Re: Planning Application M/47/14/PL
Grasmere
Ancton Lane
Bognor Regis
West Sussex
PO22 6NL

I write with regard to the above planning application. The proposed new development is fundamentally the same building proposed in a previous application, M/8/14, and we object to the proposed replacement dwelling for the following reasons.

DRAWING TITLE: PRO SITE PLAN	DRG NO: PL06
DATE: JUNE '14	REV: .
SCALE: 1:250	DRAWN BY: CW

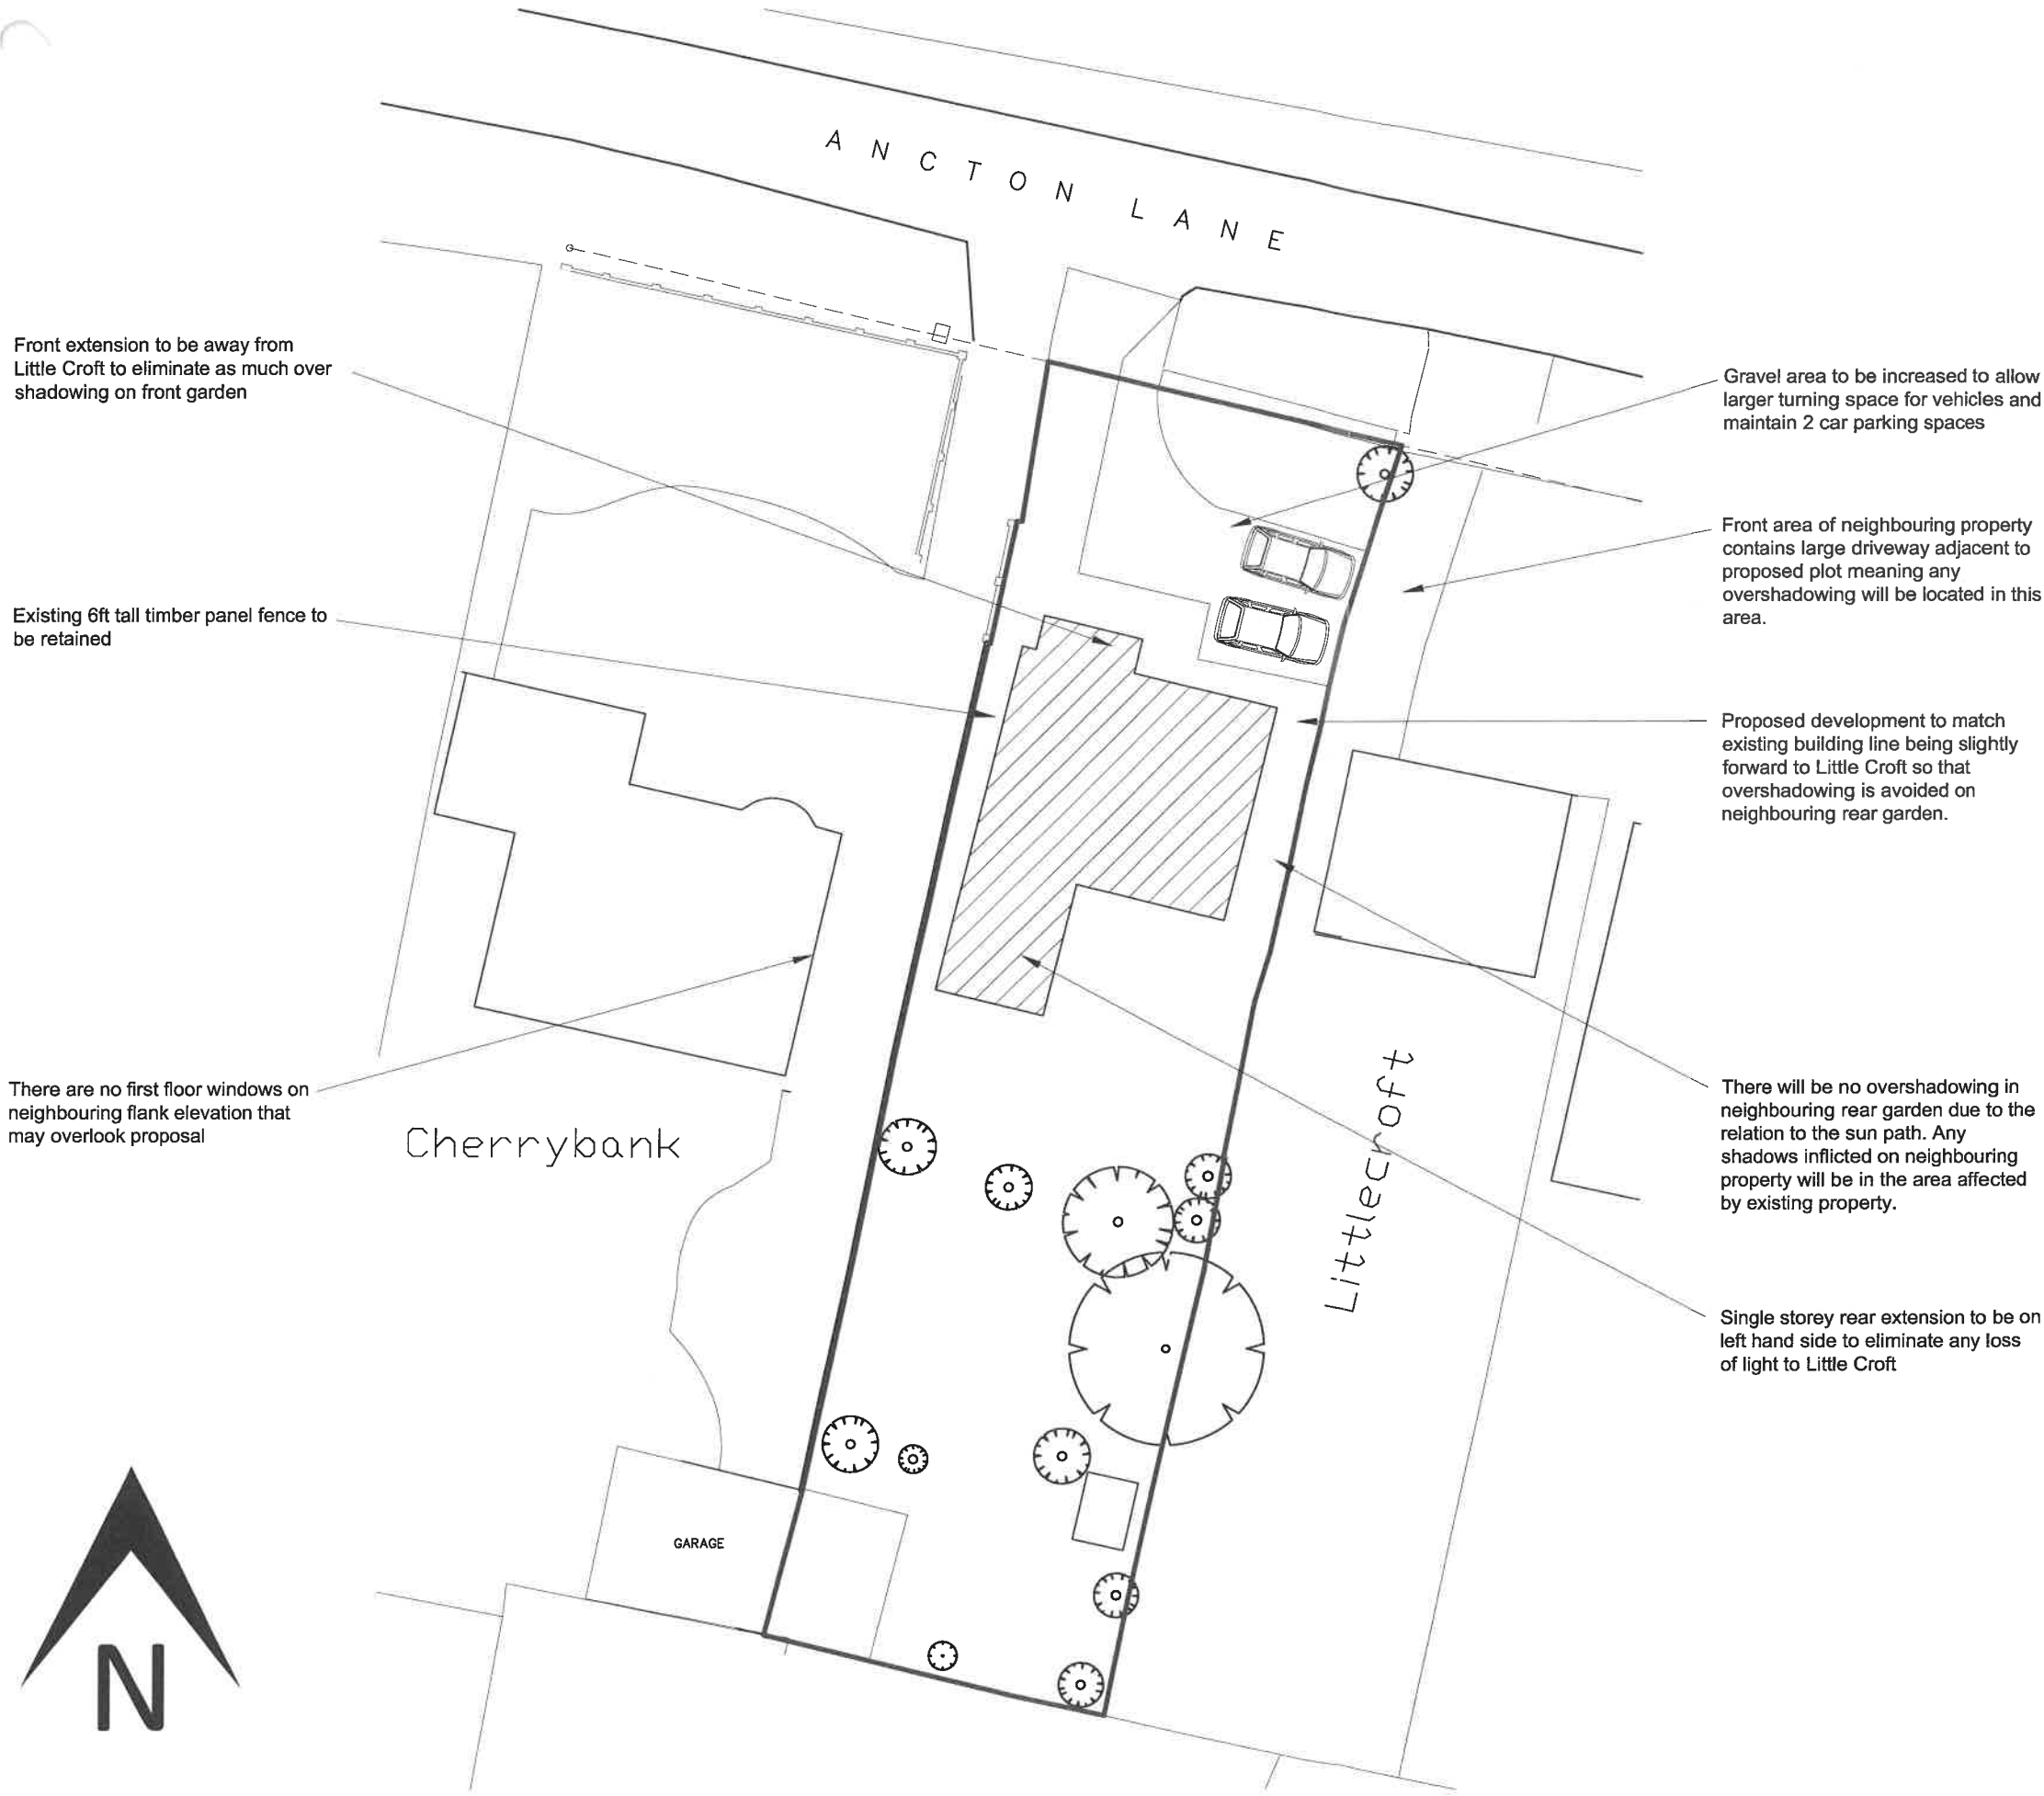
1. The new dwelling is an over development of the site and of a scale that is not in keeping with location, neither is it in relation to all the remaining properties in the lane to the East of the proposed development which it is immediately adjacent to (Little Croft, Greenbanks, Petite Etoile and Hazelbanks). It is comparable in height and visual impact to the house to the West (Cherrybank), although owing to lack of clarity on the street scene elevations it is difficult to ascertain the precise height. Cherrybank is set further back than the bungalow it replaced and is on a much larger plot, with its building line matching the properties to the West of it, so as not to be overbearing on the street scene and the single storey properties to the East. The proposed new dwelling would dramatically alter the street scene. The attempt to alleviate concerns with regard to adjacent properties by placing the building further forward in the plot increases the overbearing impact on the street scene without giving sufficient relief for surrounding properties. With regard to the ridge height it seems logical that the proposed dwelling should be set back, not forward, in the plot to be in keeping with scale, street scene and previous developments.
